KITTITAS COUNTY COMMUNITY DEVELOPMENT SERVICES

*Trinity Farms
2451 81 Road
Ellensburg WA 98926*

RE: *BL-14-00006 Trinity Farms, Additional Information Request*

Forman / Shelton BLA

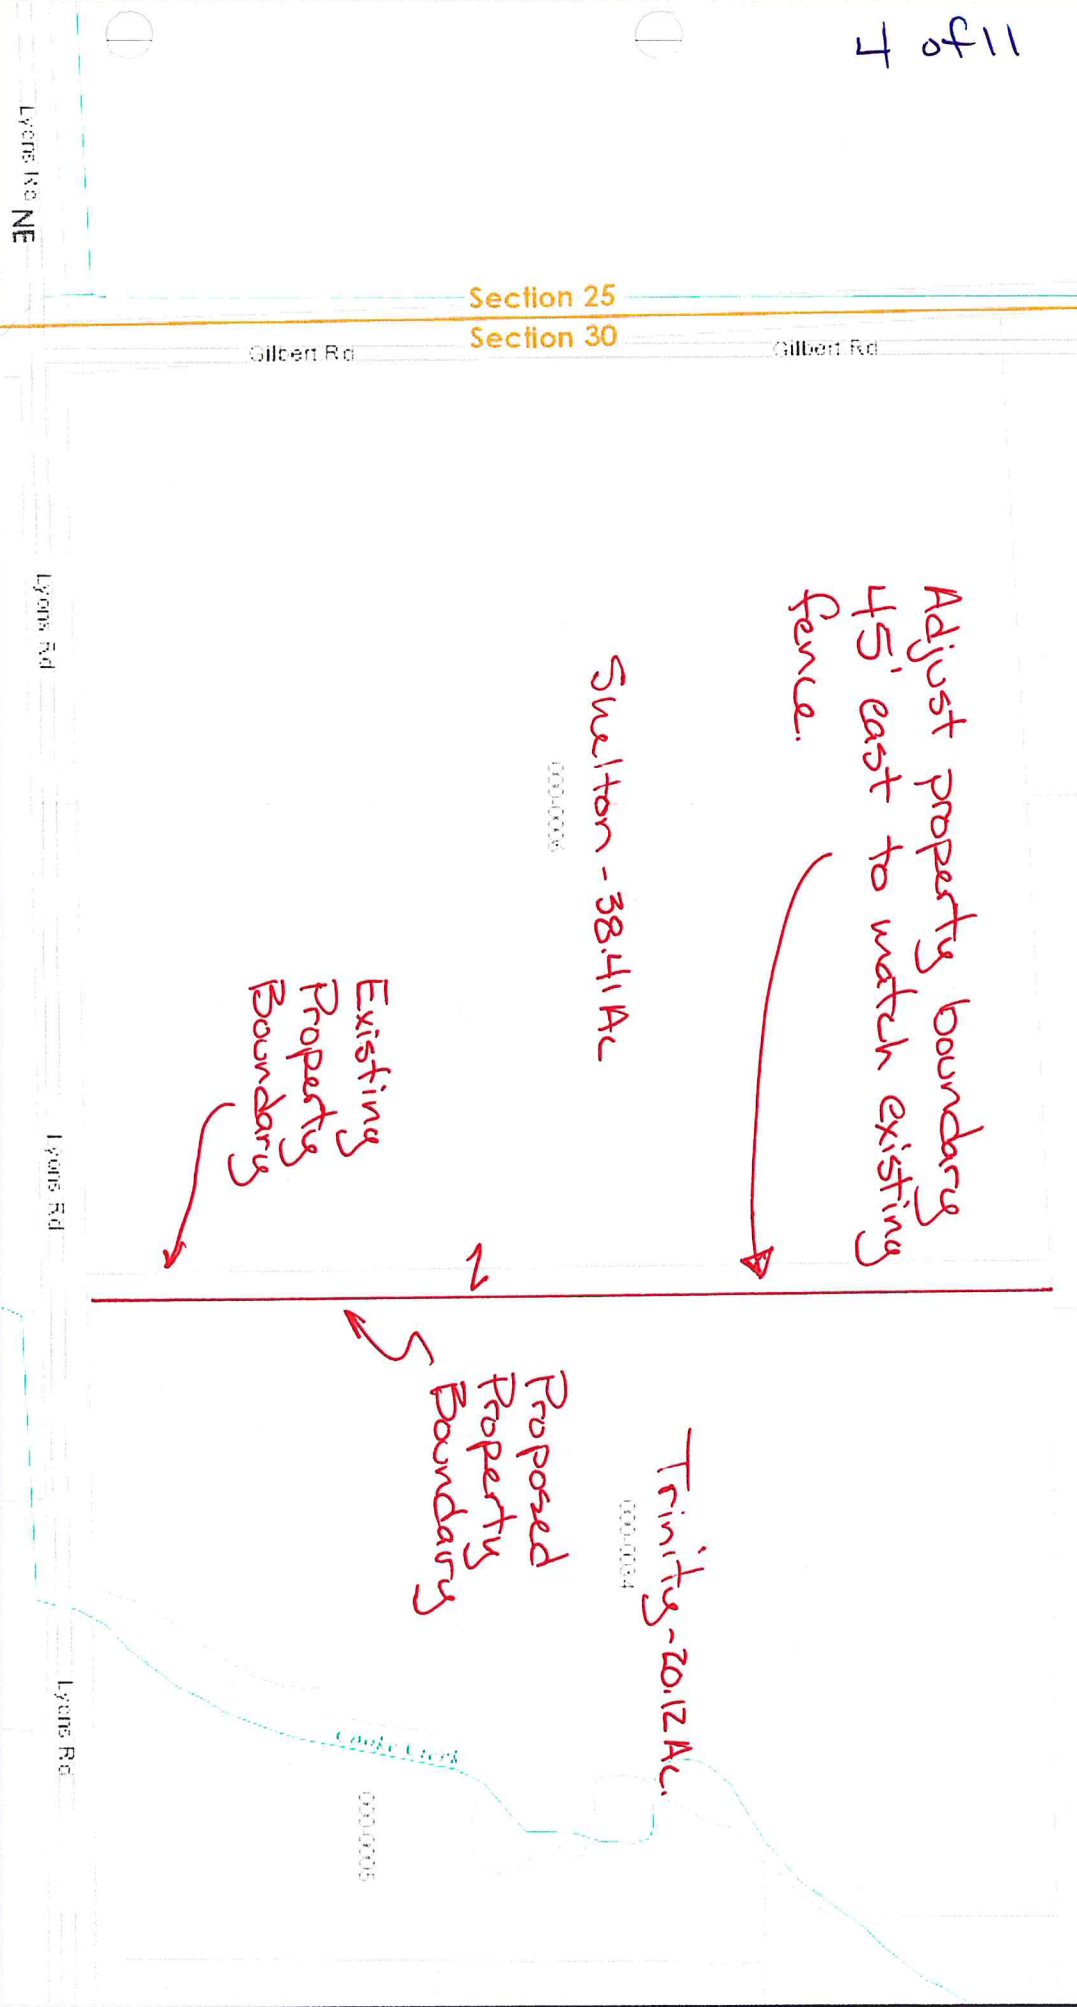
- *Kittitas County Environmental Health has required a site plan indicating where all existing wells and septic systems are on all properties associated with the boundary line adjustment.*
